CUMBERLAND
CITY COUNCIL

Our Ref: OA2020/0002
DPIE Ref: SSD-10399

Subject: Request for Comments - State Significant Development (SSD)
Application No: SSD-10399
Property: 44 Clunies Ross Street & Great Western Highway, PROSPECT NSW 2145
615A Great Western Highway & Boral House – Clunies Ross Street,
PEMWULWUY NSW 2145
Proposal: Proposed warehouse and logistics estate at Clunies Ross Street,
Pemulwuy, including the construction and operation of seven warehouses
ranging in height from 11 metres to 42 metres, with a combined gross floor
area of circa 96,000m²

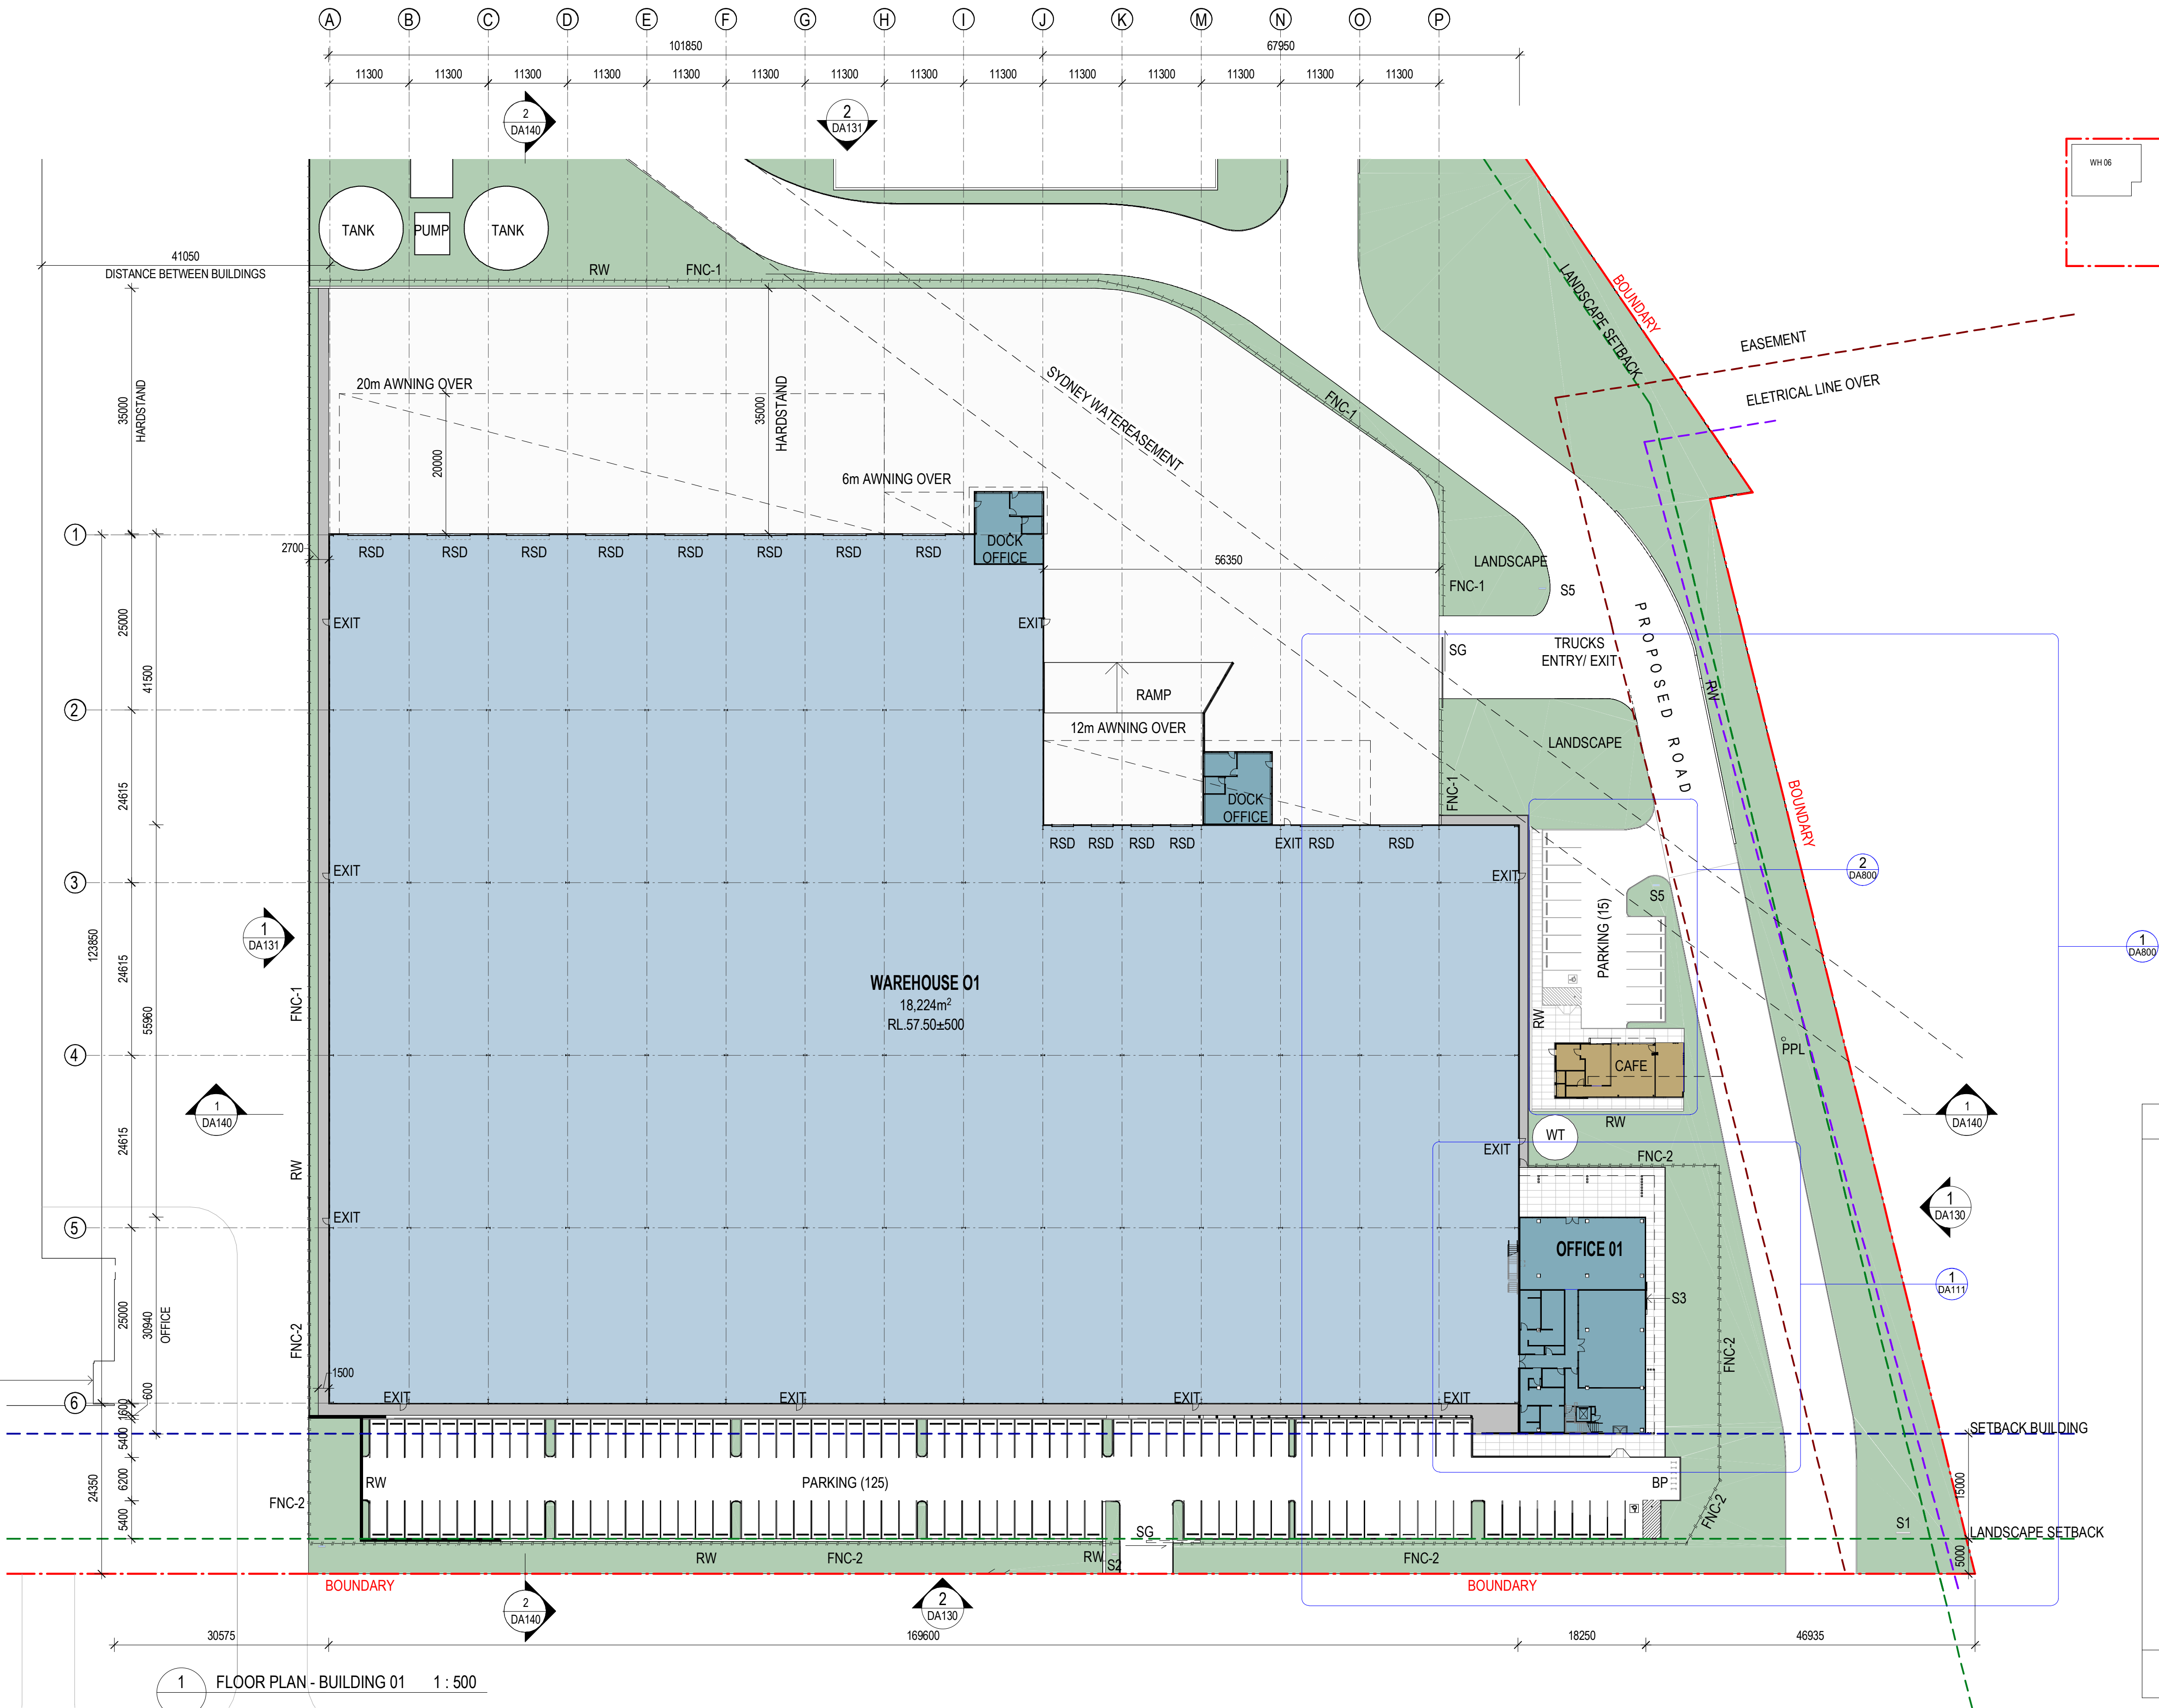
In this regard, the proposed development is setback 15 metres from the property boundary with Clunies Ross Street, with landscaping maintained to the first 5 metres,

which reduces opportunities for landscaping on site, and limits the landscape curtilage between the development and the public domain.

Note: The Draft Site Specific DCP submitted, further seeks to reduce the extent of landscape area required to the first 3 metres, as measured from the property boundary with Cluniess Ross Street.

30. Driveway access in the Clunies Ross Street cul-de-sac shall be modified, so as to be located away from the cul-de-sac.
31. Truck access at the Clunies Ross Street cul-de-sac, and truck access to Warehouse 6, should be perpendicular to the site boundary alignment.
32. Truck access to Warehouse 6 interferes with the existing stormwater pit and lintel. Access should be minimum 1.2m from the stormwater pit and lintel.
33. Car parking access for Warehouse 3 should be relocated away from the truck access.

1 BUILDING 1 NORTH ELEVATION 1 : 250

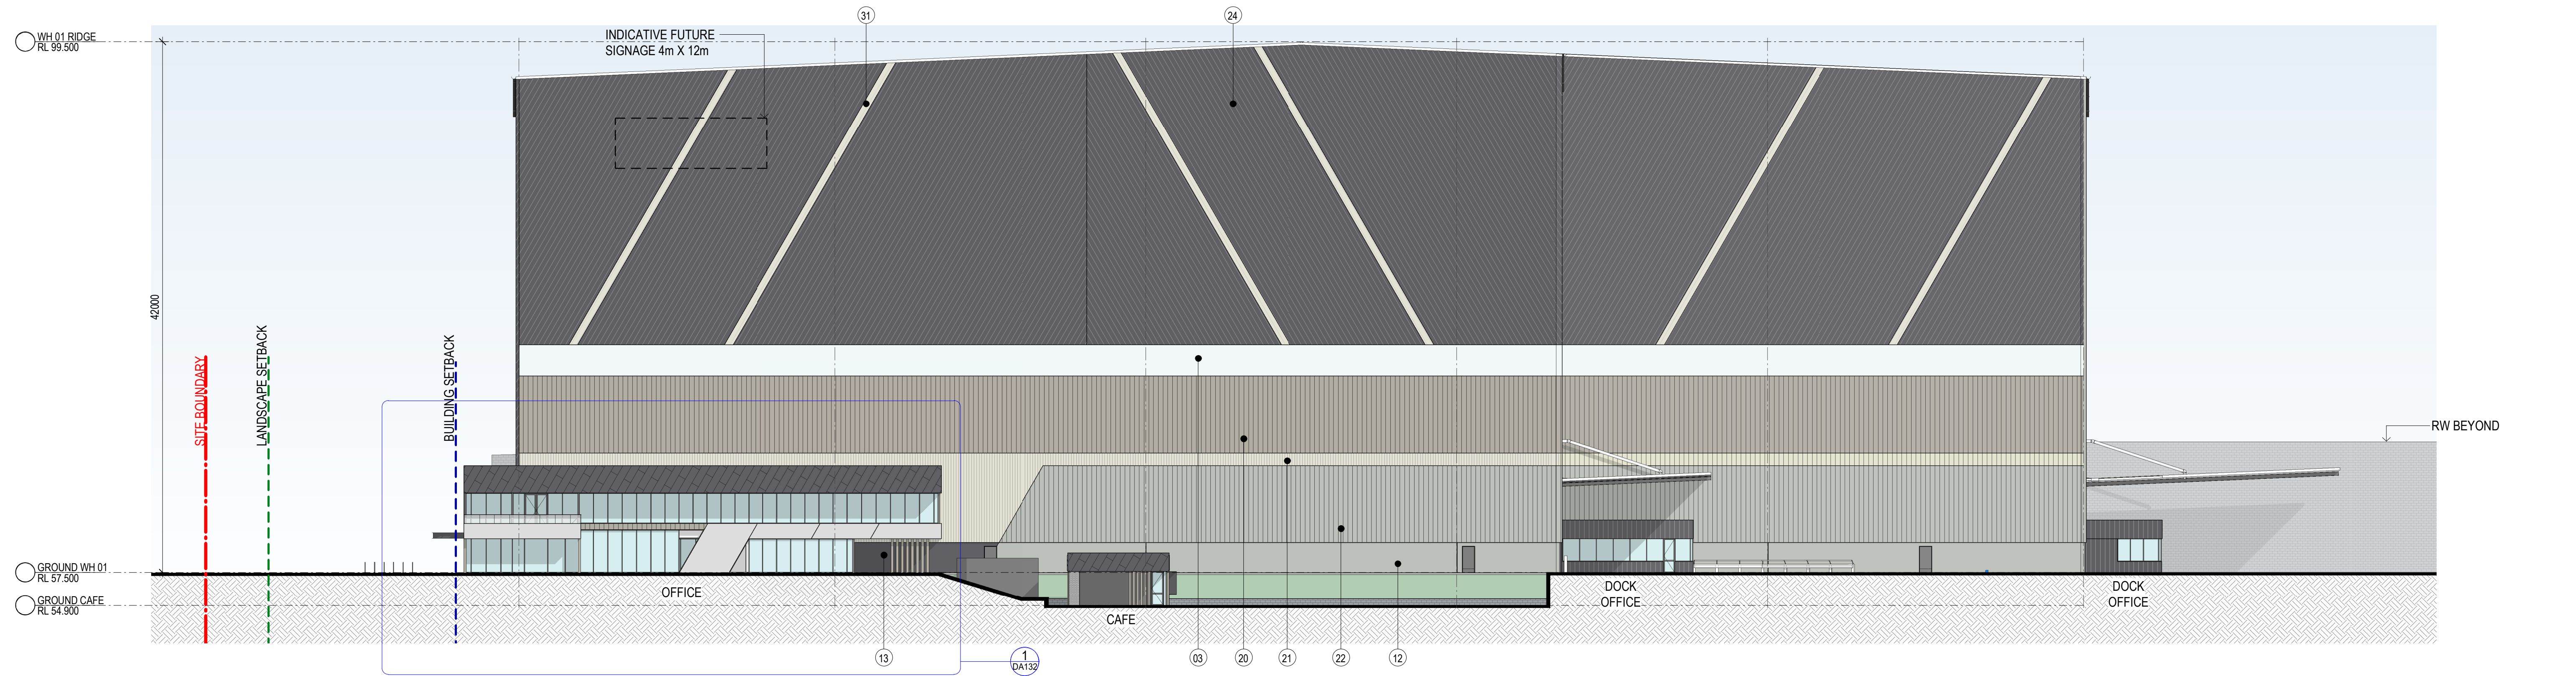
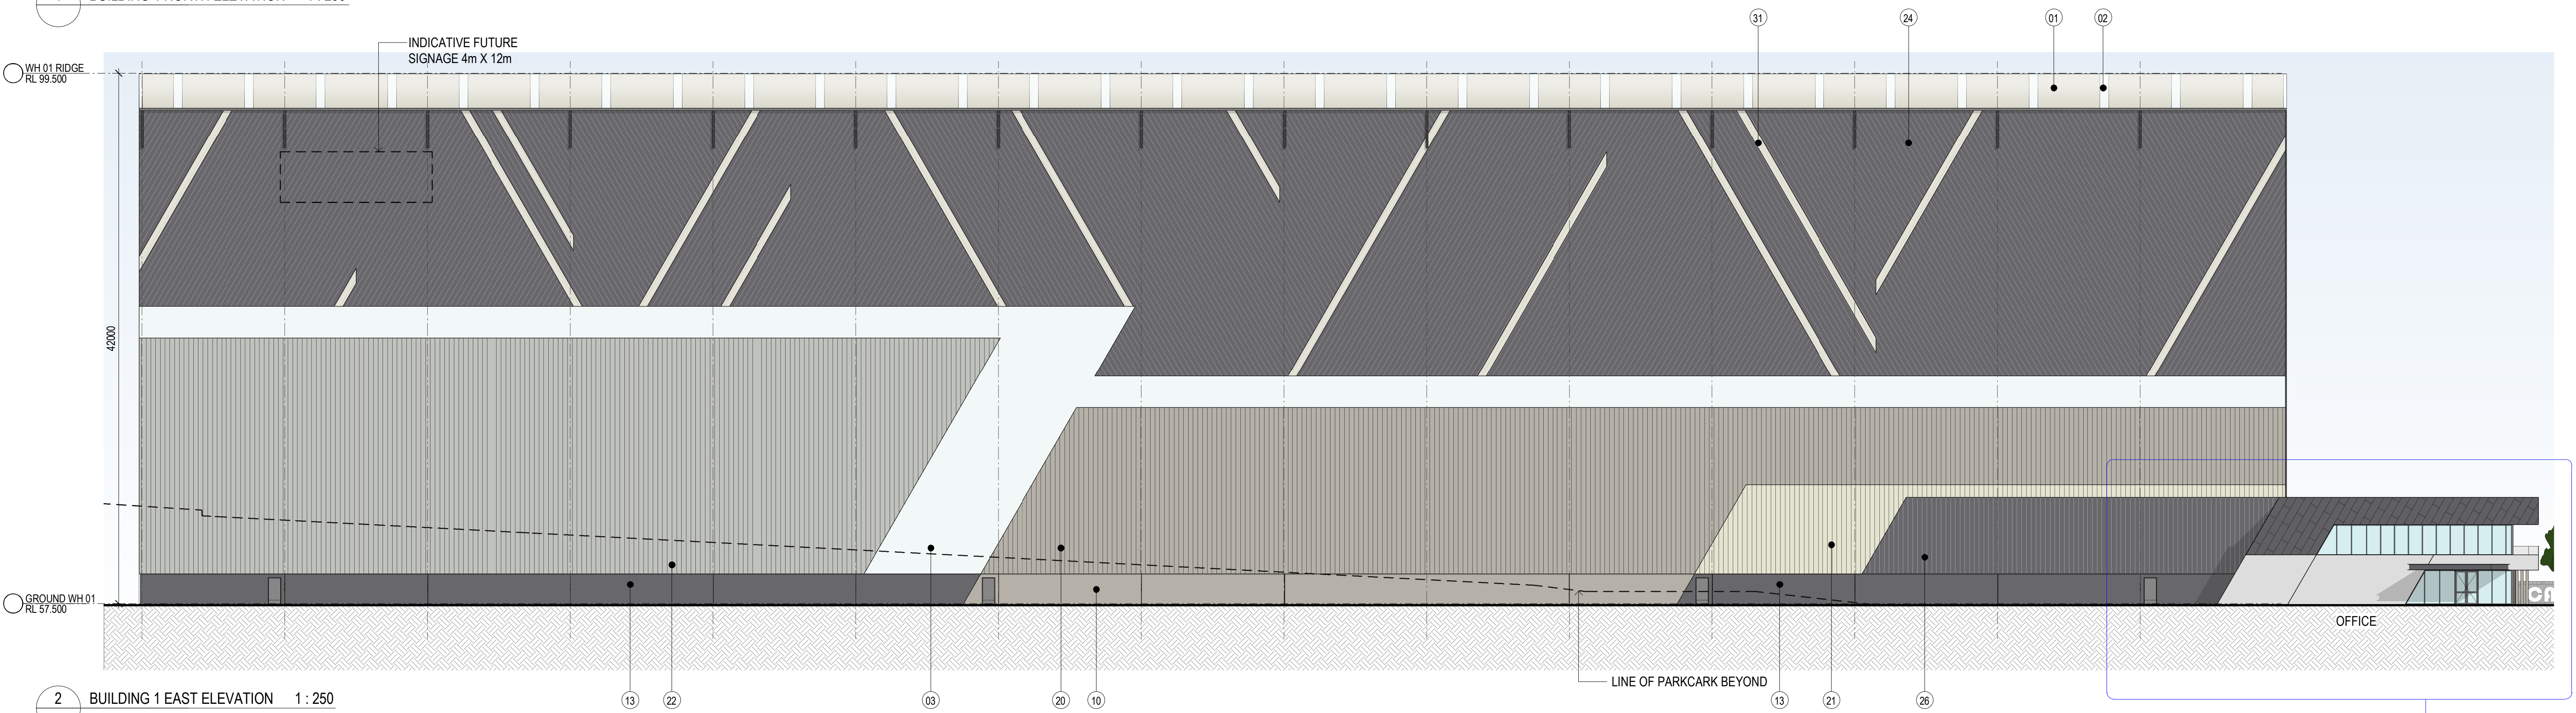
In this regard, the proposed development is *designed to a maximum height of 11.7m and 42m above the amended ground level*, as identified within Page ix of the Environmental Impact Statement (EIS), which is considered excessive, and out of character with the surrounding area, in particular the interface with, and views towards, Prospect Hill, and the existing residential area to the east of the site.

Note: Page 60 of the Statement of Heritage Impact (SoHI) identifies *Warehouse 1 will be the highest of the proposed development, extending to a height of RL 99.5. ... This structure may however obscure views towards Prospect Hill when viewed from the north of the development. ... The proposed works would also reduce the prominence of Prospect Hill as a landscape feature when viewed from surrounding areas.*
